Ribble Valley Borough Council
Church Walk,
Clitheroe,
BB7 2RA

Phone: 0300 123 6780
Email: lhscustomerservice@lancashire.gov.uk
Your ref:
Our ref: LHS/CS/3/2016/0206
Date: 23rd March 2016

Proposal:	Proposed replacement dwelling
Location:	Robin Hill Talbot Bridge Bashall Eaves Clitheroe Lancashire BB7 3NA
Grid Ref:	369914 - 443862

With regard to your letter dated the 8th March 2016

SITE PLAN

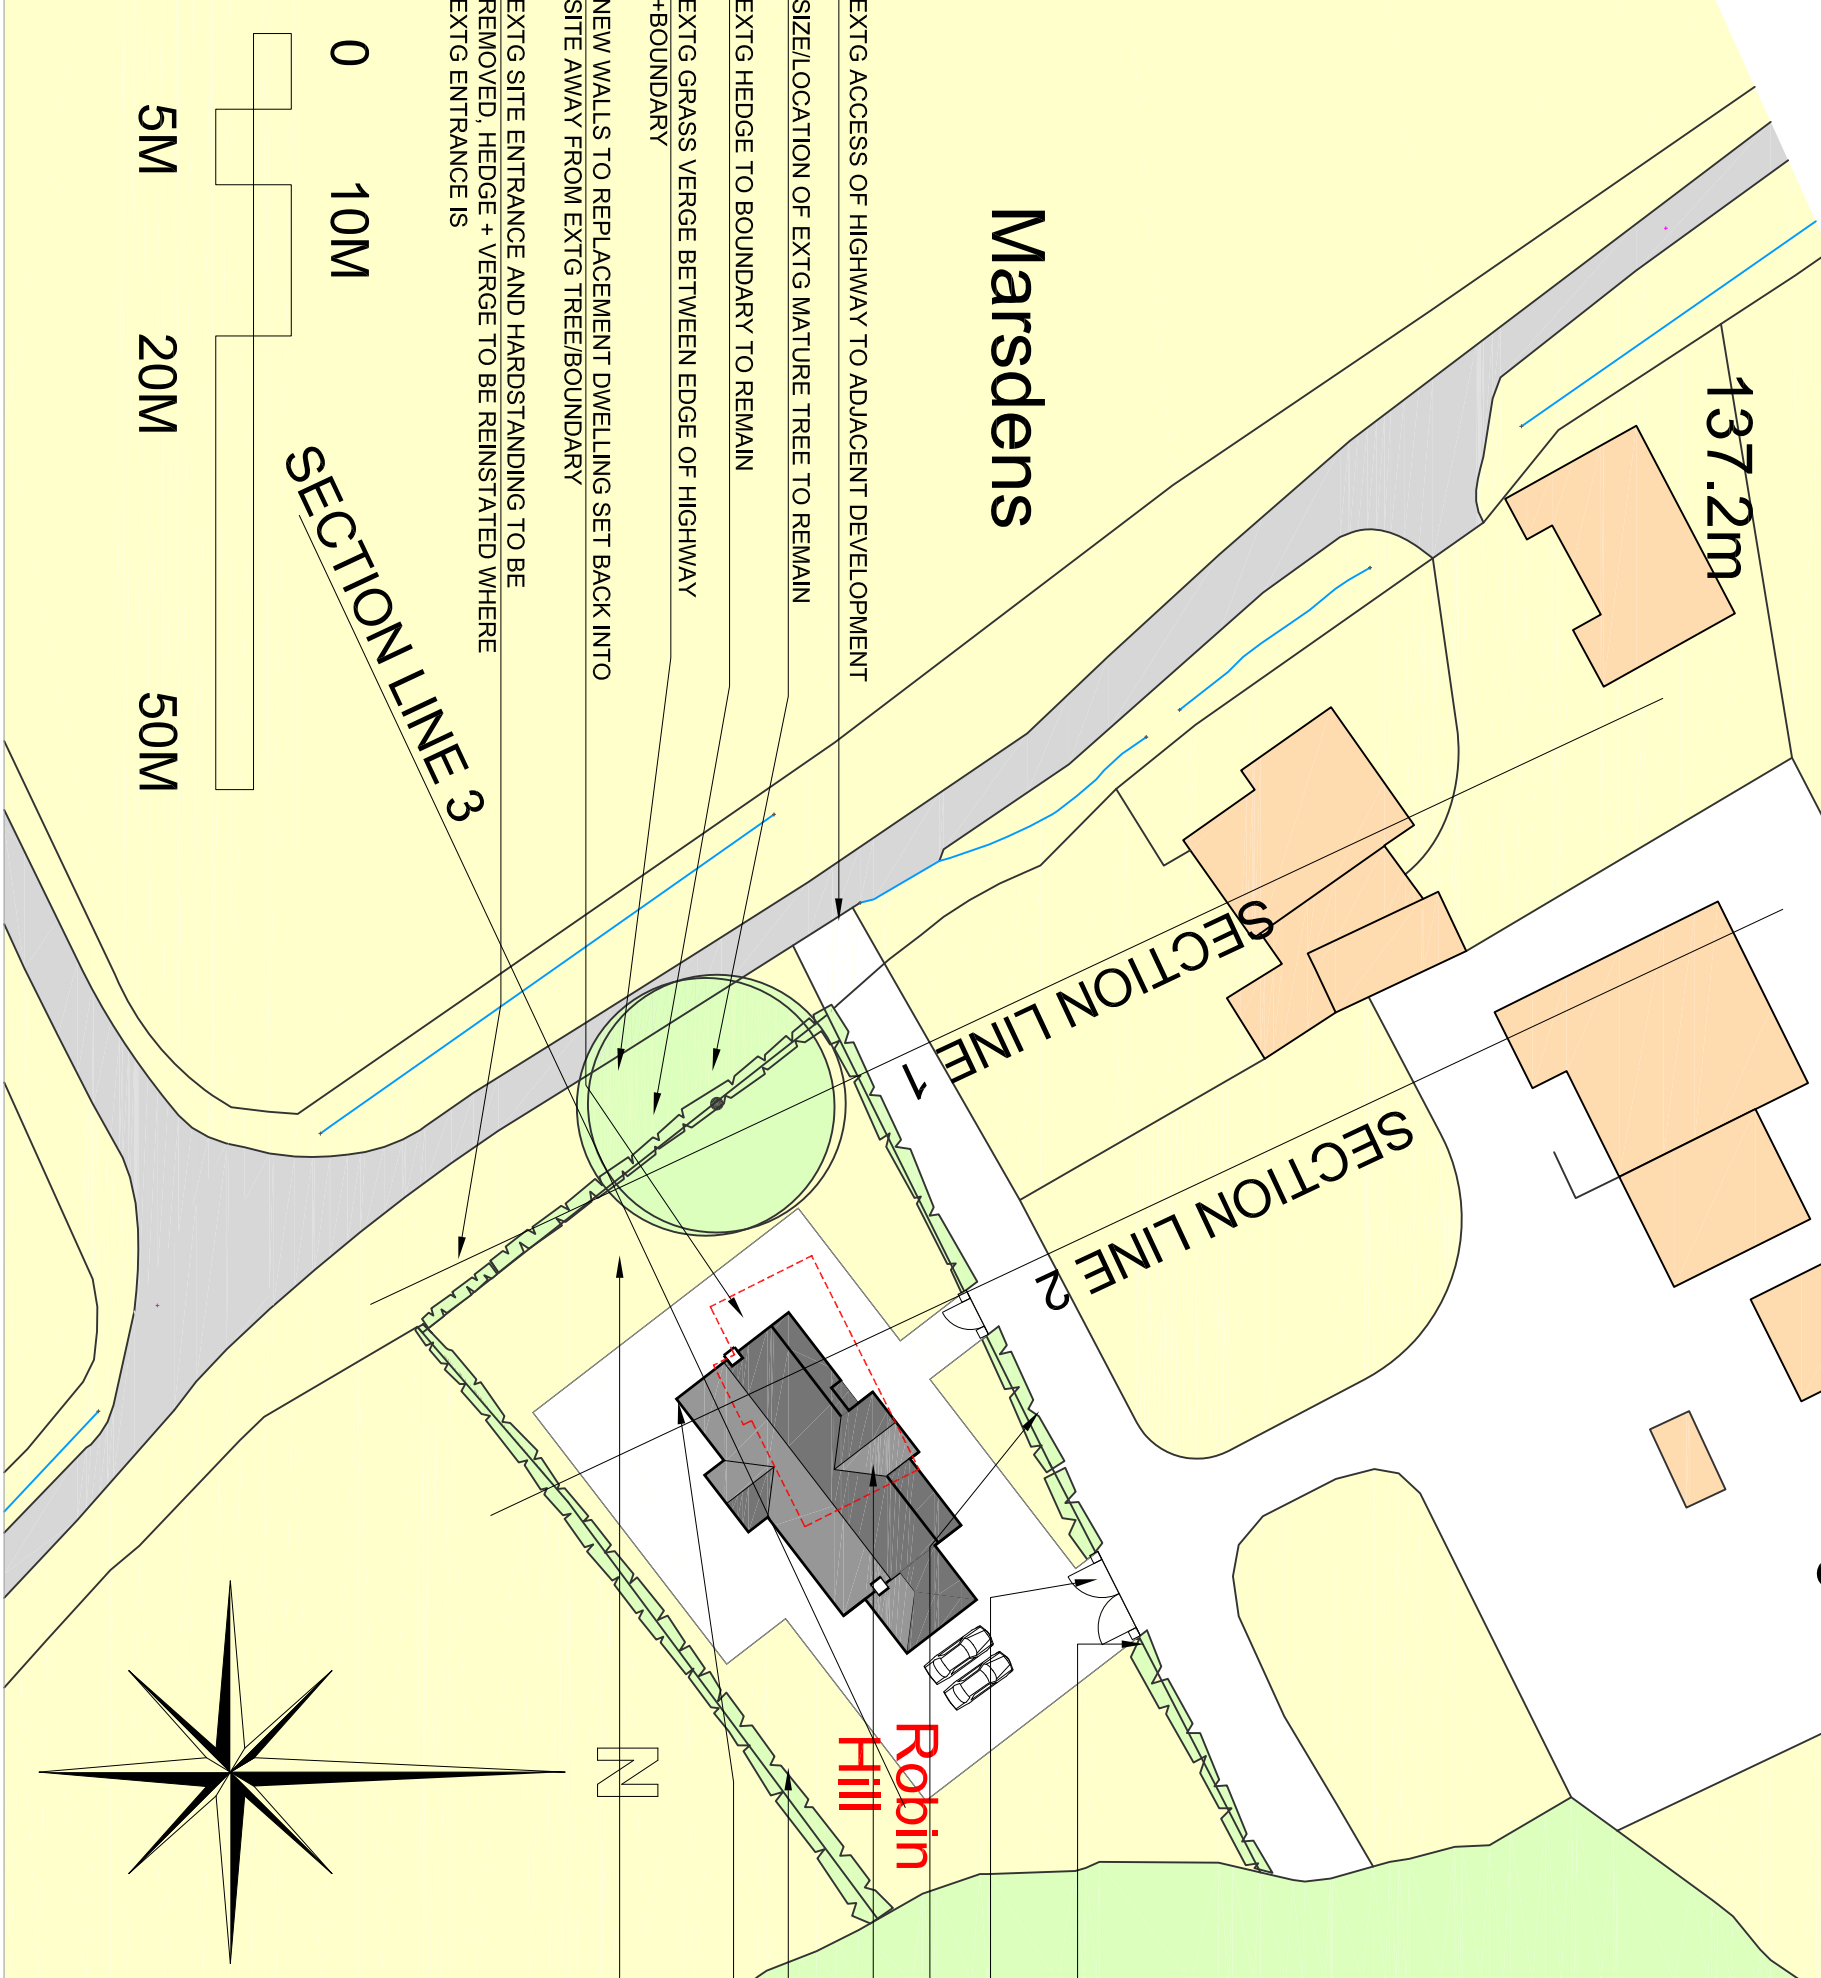
The sightlines from the drive onto the rear of the approach road edge of carriageway to be 3.0x3.0m, measured from the centre of the drive, to provide better protection for pedestrian and neighbouring vehicles passing the access.

1. Before the access is used for vehicular purposes, 45° visibility splays shall be provided between the highway boundary and points on either side of the drive measured 3m back from the nearside edge of the carriageway. Reason: To permit vehicles to pull clear of the carriageway when entering the site and to assist visibility.
2. The car parking and manoeuvring scheme to be marked out in accordance with the approved plan, before the use of the premises hereby permitted becomes operative and permanently maintained thereafter. Reason: To allow for the effective use of the parking areas.
